Offshore Wind Farm

Five Estuaries' Applicant's Comments on Natural England's Deadline 4 Submissions - Revision A

Document Reference: 9.61 Volume: 9

10.34.1 APPLICANT'S COMMENTS ON NATURAL ENGLAND'S DEADLINE 4 SUBMISSIONS

Figure 2 Indicative maximum fence line and associated works

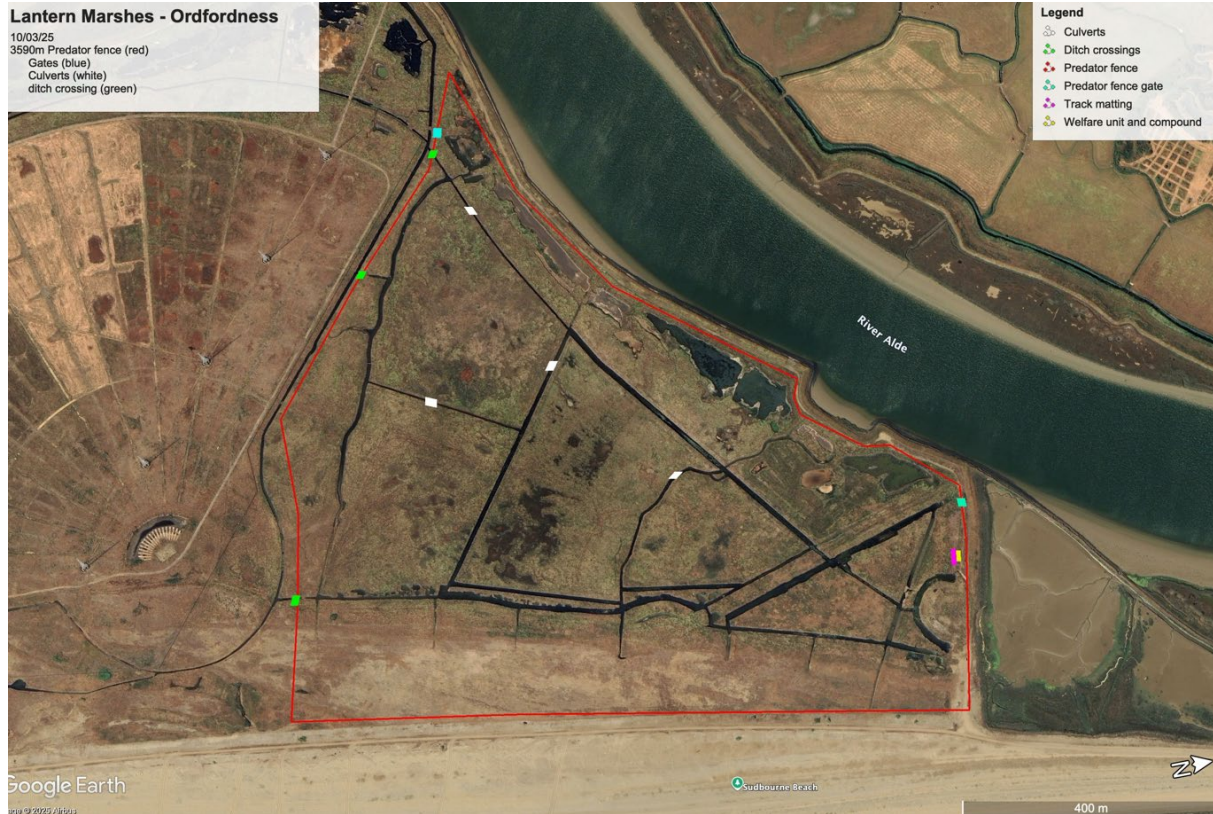
NE41	J11 – The Applicant considers that there is no requirement to reconsider the conclusion of no LSE for fence installation based on the assumption that the site has already been modified and the delicate matrix already impacted. However, this does not preclude the presence of rare and sensitive shingle flora and fauna associated with the SAC, and new survey data should be acquired to support this conclusion. J11 - Baseline surveys are needed to confirm current sensitivity of shingle habitats before conclusions can be agreed.	This is noted by the Applicant, please see Response to NE31 and below. No rare species of flora have been found during the surveys and most of those found along the proposed fence line are not sensitive, the exceptions being lichens which could take some time to recolonise disturbed areas. There are populations of rare invertebrates present in proximity to the PCS. These are associated with open habitats (and pieces of timber therein) rather than the dense stands of sea couch and false-oat grass which dominate the area. The proposals include mitigation to protect rare and sensitive species, and the other species would recover quickly from the disturbance as evidenced by existing fence lines within the SAC.

NE42	J12 – The Applicant states that because the morphology has already been modified, it considers that impacts of fence installation and maintenance do not need to be included in EIA. However, this will be included the implementation and monitoring plan. J12 - Resolved.	This is noted by the Applicant.
NE43	J13 – The Applicant has stated that the new fence line will avoid saline lagoons. Climate change impacts have also been assessed in J8. Therefore, this issue is resolved. J13 - Resolved.	This is noted by the Applicant.
NE44	J22 – The Applicant has agreed to discuss maintenance and best practice options with Natural England. J22- In progress, pending discussions.	This is noted by the Applicant.
NE45	J23 – in Para 4.4.8 [AS-040] and [REP2- 013], the Applicant states that once a colony has established, if nutrients are increased, consideration may be given to removing cut vegetation from the site, which they consider sufficient additional mitigation for any increased nutrient levels. This remains part of the maintenance plan (4.1.10 [AS-040] and 6.2.3 [REP2-103]). However, we question whether this is additional mitigation? J23 - The proposed mitigation was already secured, and we do not consider it as additional. Natural England queries if this mitigation sufficient.	The Applicant has described this as 'additional mitigation' because was not included in the original project design. The need for and sufficiency of the measure will be determined by monitoring. Regardless, any increase in nutrients would be no more than that derived from the stated conservation objective to restore the gull breeding colony within the SPA.
